Ribble Valley Borough Council
Housing & Development Control

Your ref: 3/2024/0093
Our ref: D3.2024.0093
Date: 20th May 2024

Application no: **3/2024/0093**

Proposal: **Proposed removal of existing modular contractors buildings and
fencing. Installation of replacement 3m high fencing and modular welfare and office
buildings.**

title: **PROPOSED SITE LAYOUT
PROPOSED GA**

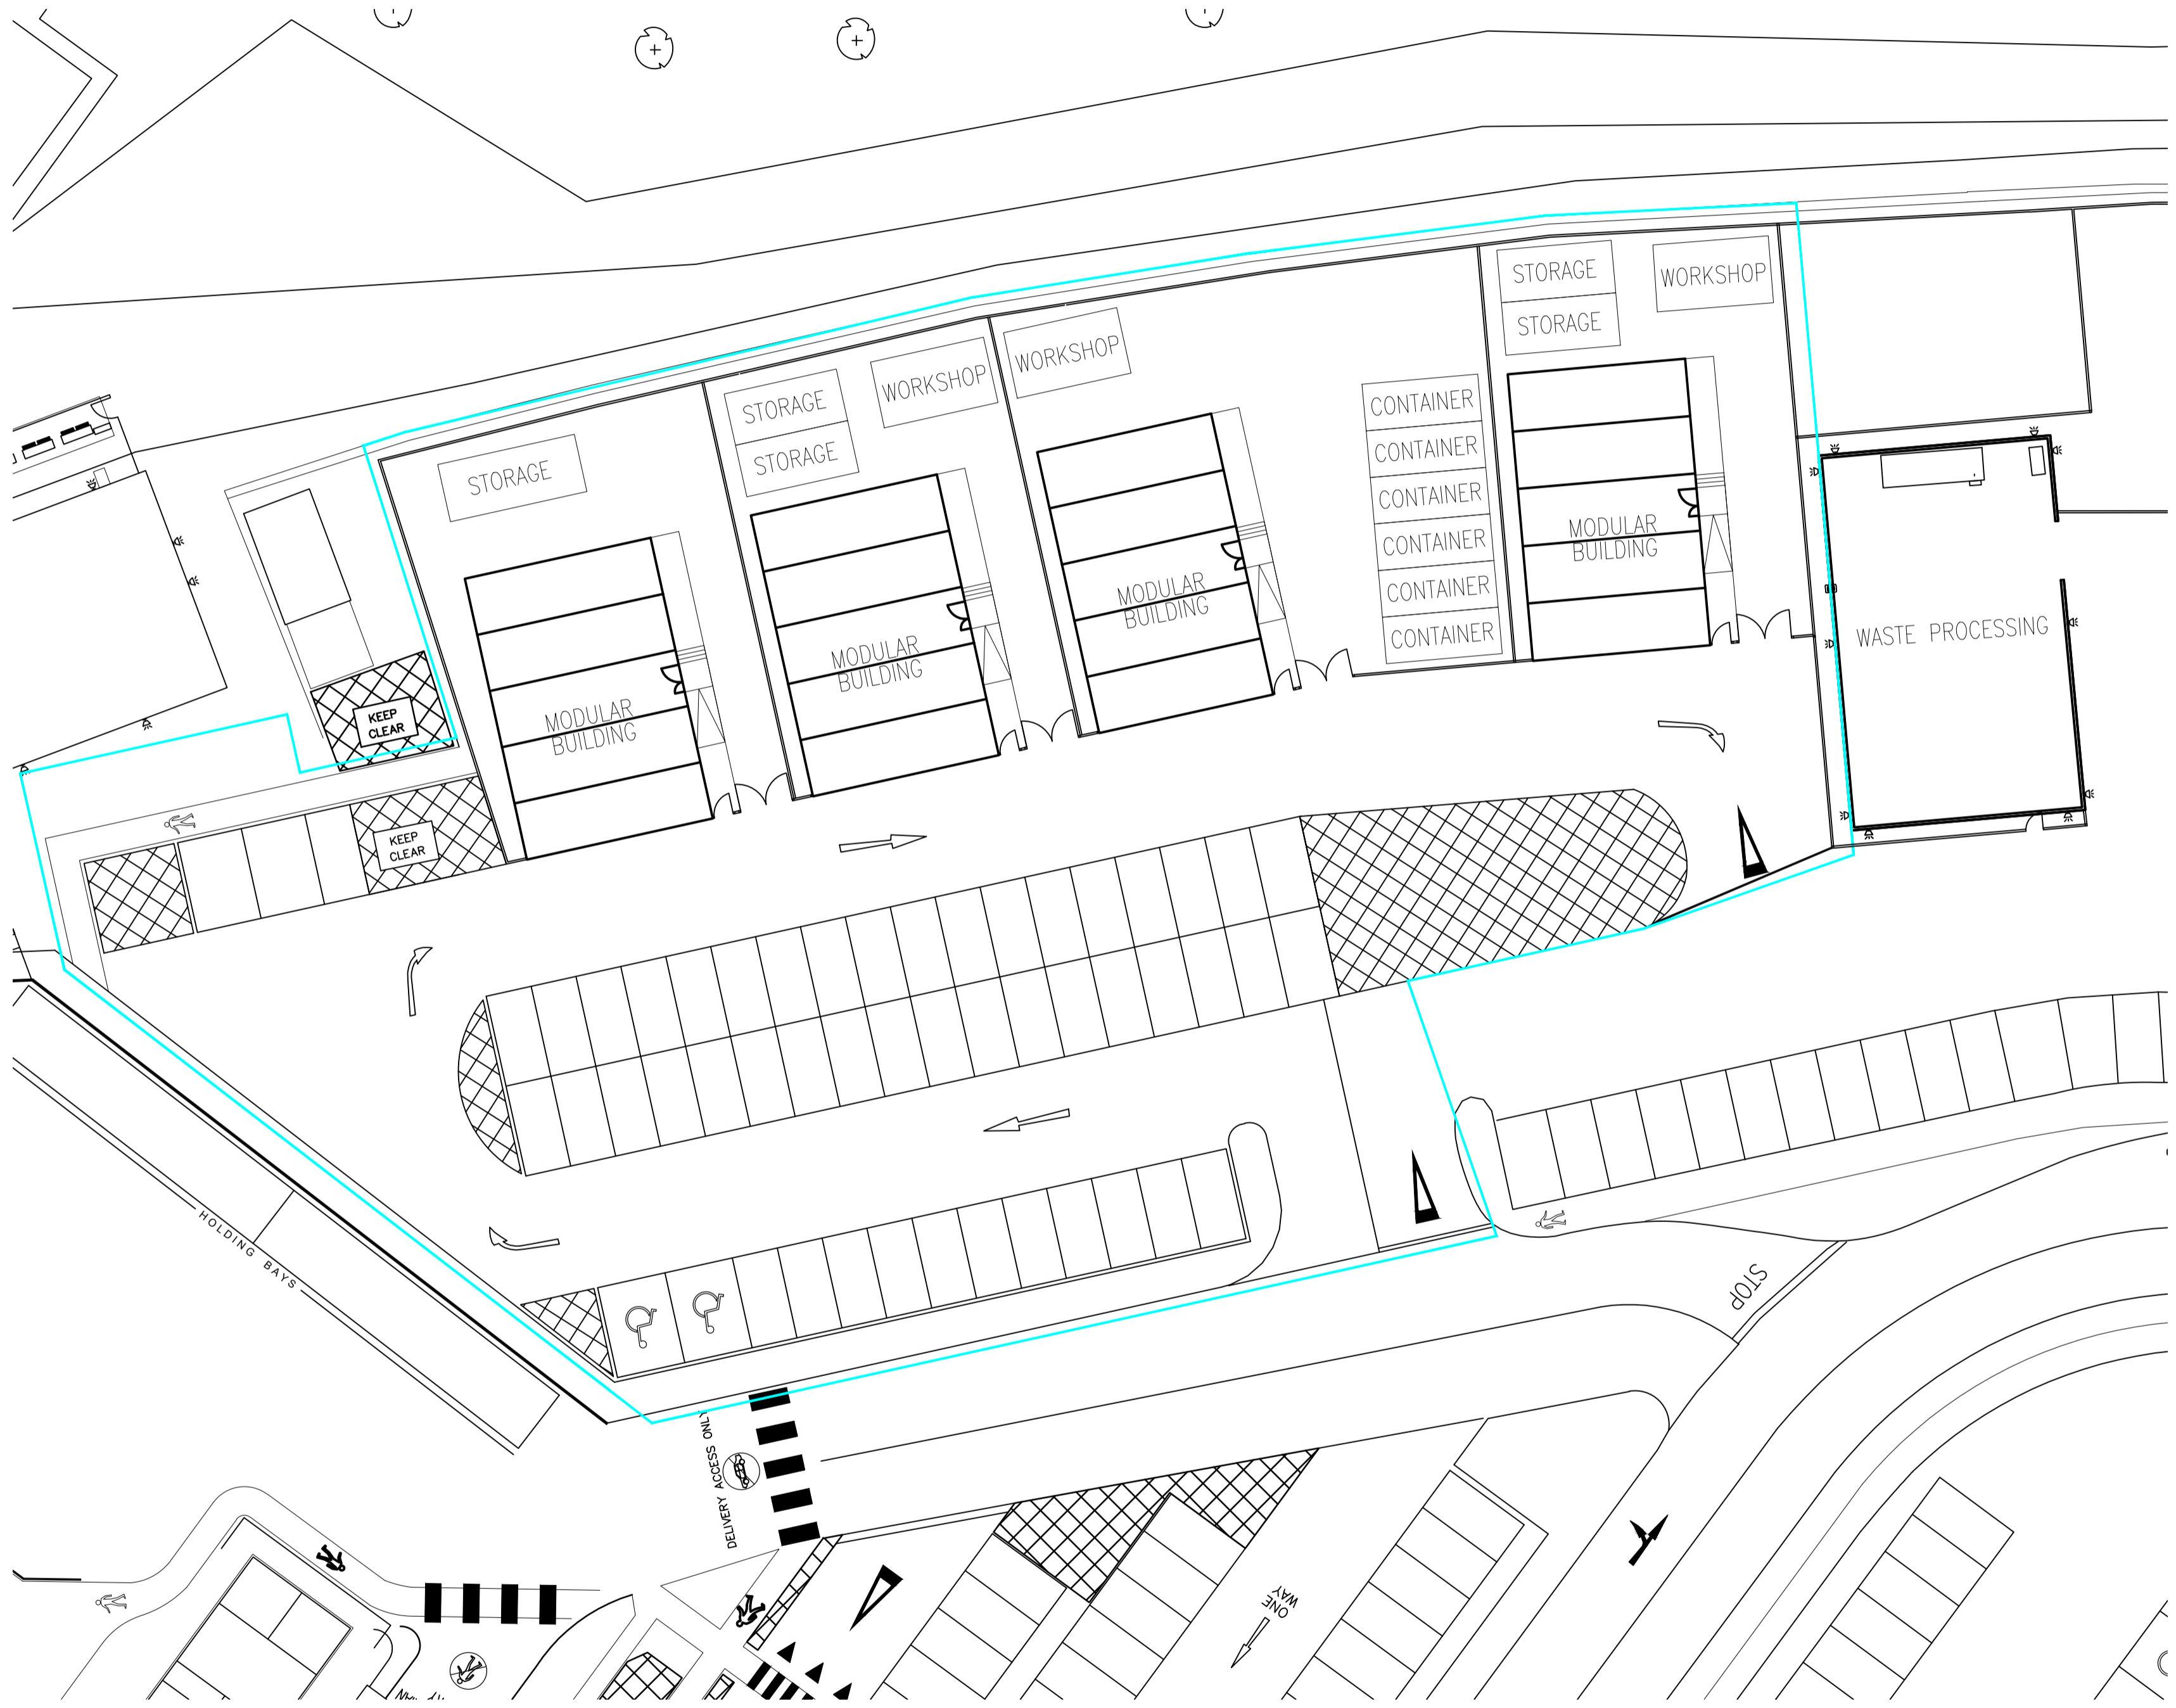
The LHA have reviewed the supporting documents and Wilson Mason drawing number P_7235L(1-)04 Rev 05 titled "Proposed Site Layout-Proposed GA" and are aware that the parking area located adjacent to the site has access to 112 car parking spaces. As explained within the Transport Note, the parking area and parking areas throughout the site are not designated to anyone. This means that should the area be full to capacity, contractors are able to park elsewhere within the site.

With this in mind and with the contractors already being located at the site, the LHA are satisfied that the site can provide adequate car parking facilities to cater for the proposal.

1. The development hereby permitted shall not be occupied until such time as the parking and turning facilities have been implemented in accordance with Wilson Mason drawing number P_7235L(1-)04 Rev 05. Thereafter the onsite parking provision shall be so maintained in perpetuity.
